Drainage Addendum

Site: Land to the North of Arundel Road, Fontwell, West Sussex BN18 OSF

Client: Harlequin Developments

Date: May 2026

Soakaway Test TP05

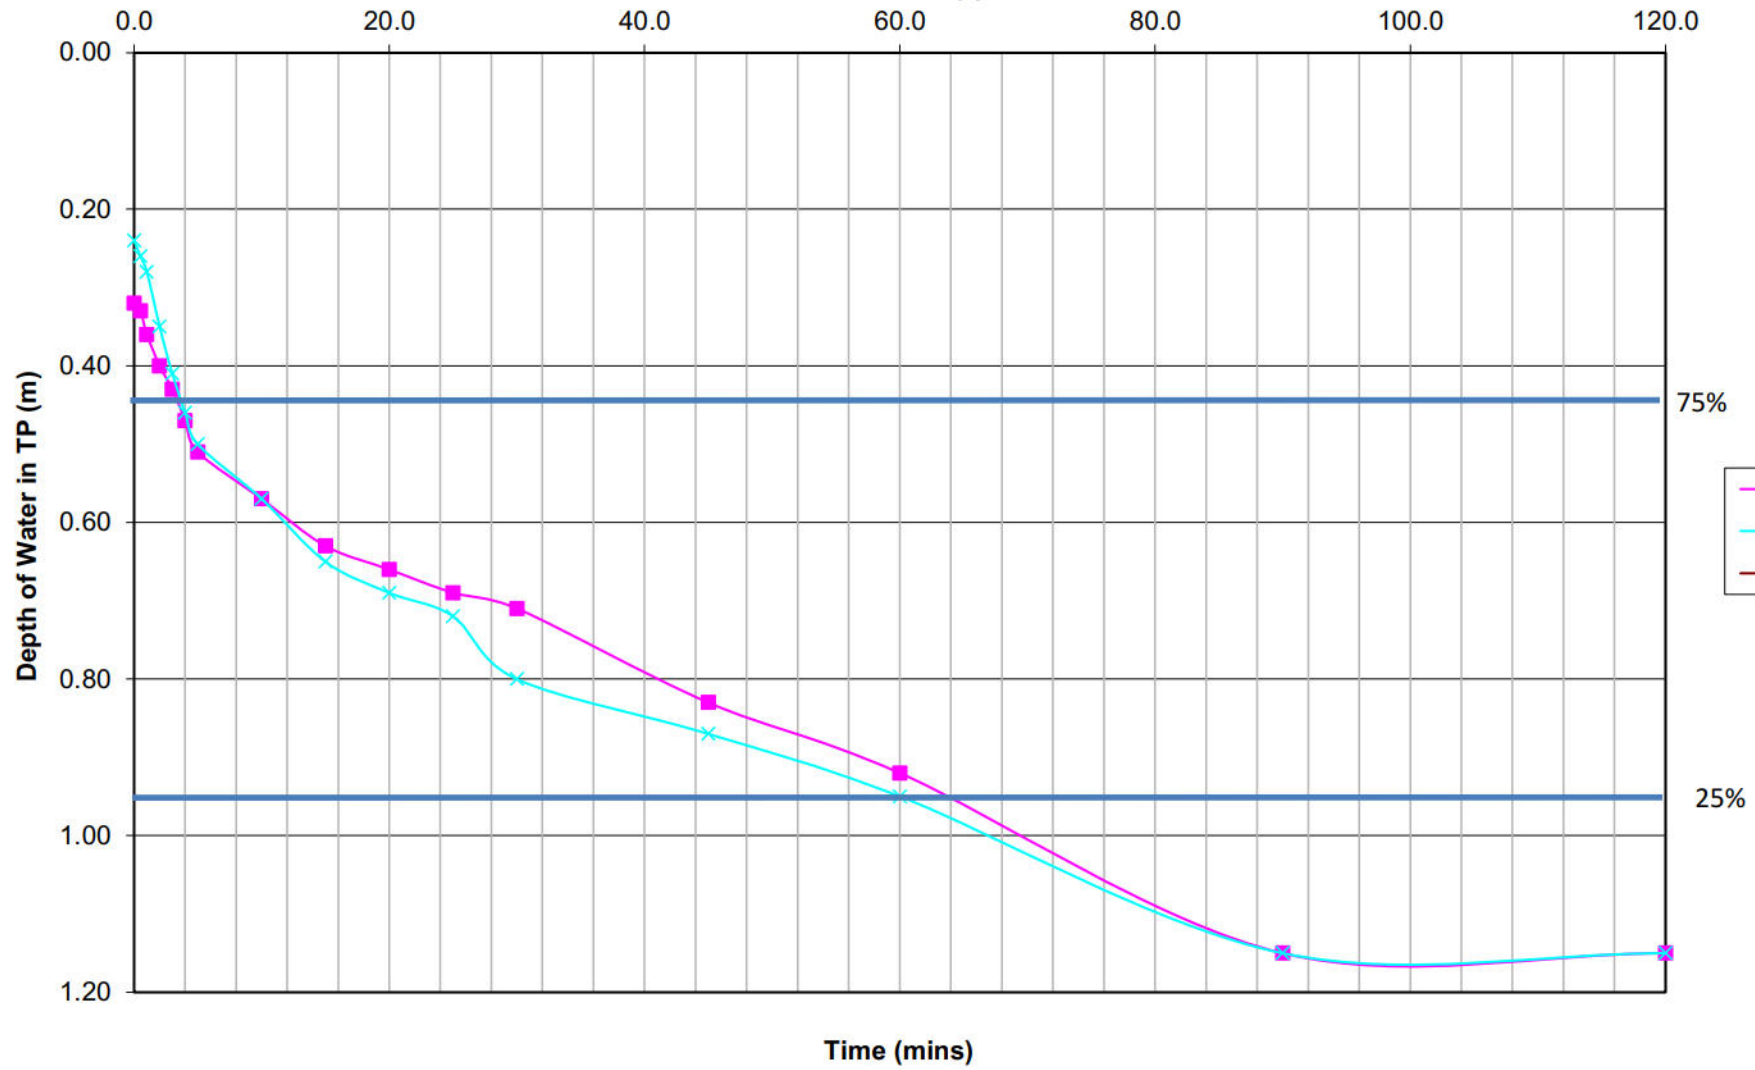
We are of the understanding that the highest recorded winter groundwater level is 1.4 mbgl in WSO6 (although we do not appear to have the full winter results submitted under this application, we are relying on Table 2 in the FRA). For TP05, where the infiltration basin is proposed to be located, only 2 tests have been completed, which does not comply with BRE365 testing standards. The proposed base of the infiltration basin is 1.2 mbgl. This therefore means there is only 0.2m between the base of the infiltration basin and the highest groundwater level. This does not comply with the National Standards for SuDS, which state that a minimum of 1m clearance between the base of any infiltration feature and the highest level of groundwater. As this is a full planning application, this is not something we are able to condition, as the drainage strategy is likely to affect the layout of the site. As previously requested, we therefore need a revised drainage strategy with an alternative method of draining the site”.

- 1.3.2 Notwithstanding the above, a revised surface water drainage strategy for the site has been prepared based on the seven-core standards and 11 underpinning principles set out in the National standards for Sustainable Drainage Systems (SuDS) dated July 2025. Compliance to the seven standards can be summarised as follows.

- 1.3.14 WSCC have confirmed that if infiltration is not considered an option that they would accept a limited discharge into their highway drainage at an attenuated rate given the site currently drains onto the highway. A record of the location of the highway drainage along with a detailed survey are contained in **Appendix C**. Correspondence with WSCC is also contained in **Appendix C**. A rate of 2 l/s/hectare equating to 5.5l/s which is less than the greenfield rate has been used in the design of the surface water drainage.
